**From:** F. Jackson Yonce <fjyonce@aol.com>  
**Sent:** Sunday, January 10, 2021 7:13 PM  
**To:** Ryan Howser; donnayonce@yahoo.com  
**Subject:** Forest Heights Circle Subdivision

#### COMMENTS / QUESTIONS REGARDING FOREST HEIGHTS SUBDIVISION

FOREST HEIGHTS CIRCLE
STA 11+50 TO 24+19

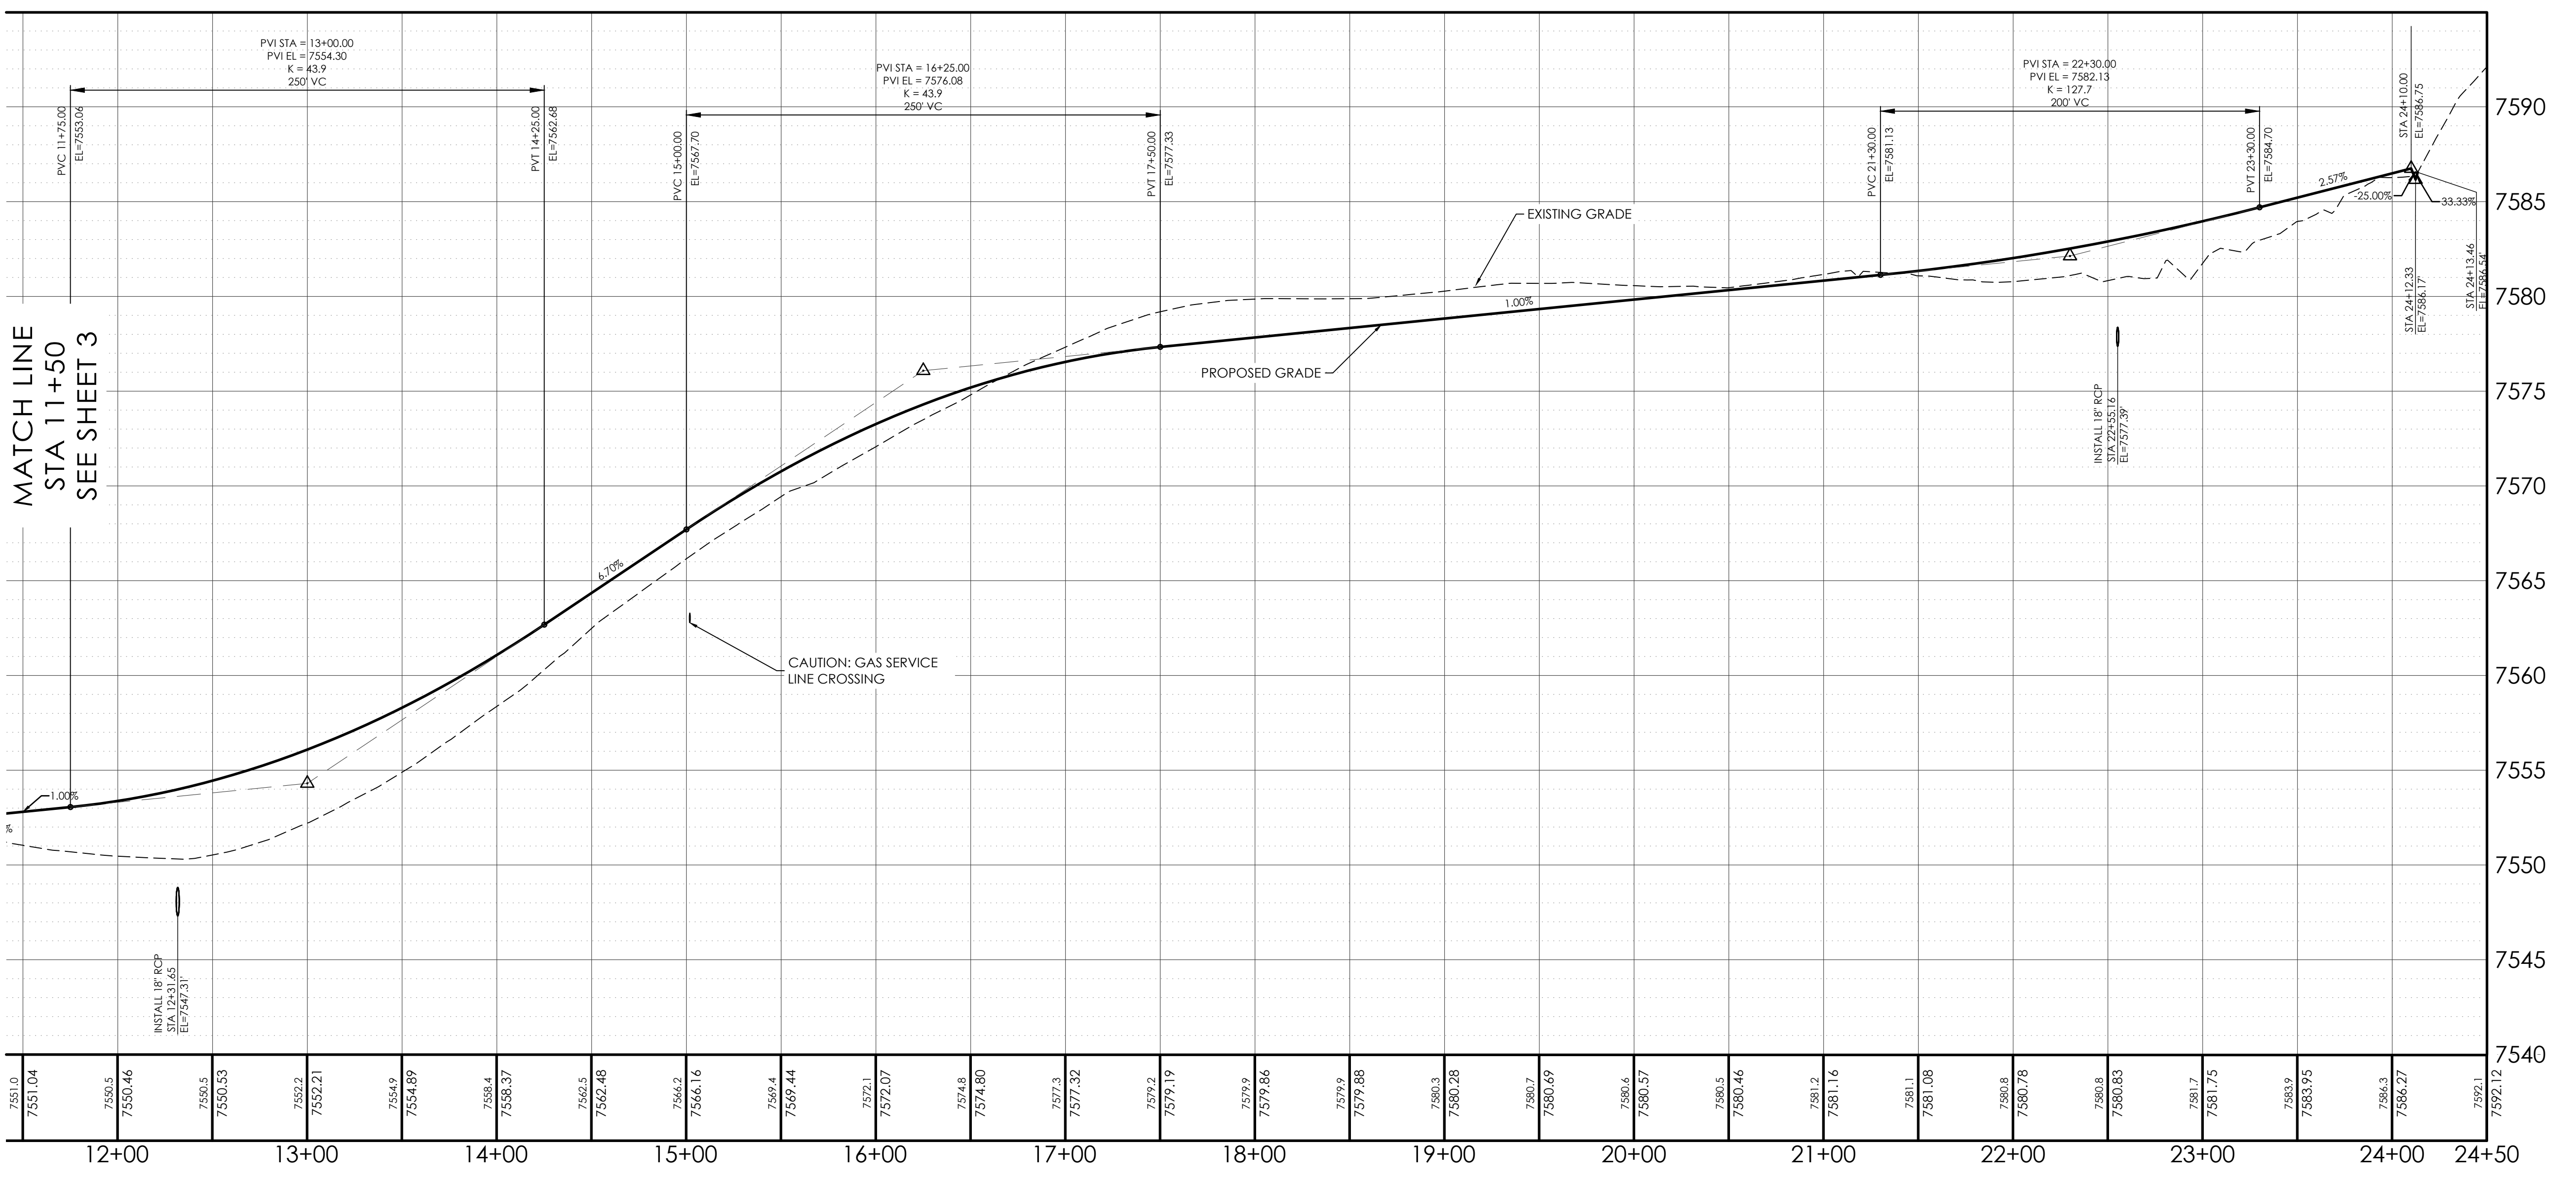
2. Since I own the road, I want it clear in the documents that any road design on my property be approved by me. Furthermore, I have discussed with Jon Didleaux my desire to have the road moved to the south where it is on my property. There is actually quite a bit of vegetation (including trees) along the north side of the road that I want preserved - we lost too much in the fire and I don't want any more removed. I have discussed this amicably with Mr. Didleaux and he agreed, however I would like that in writing in the legal documents.
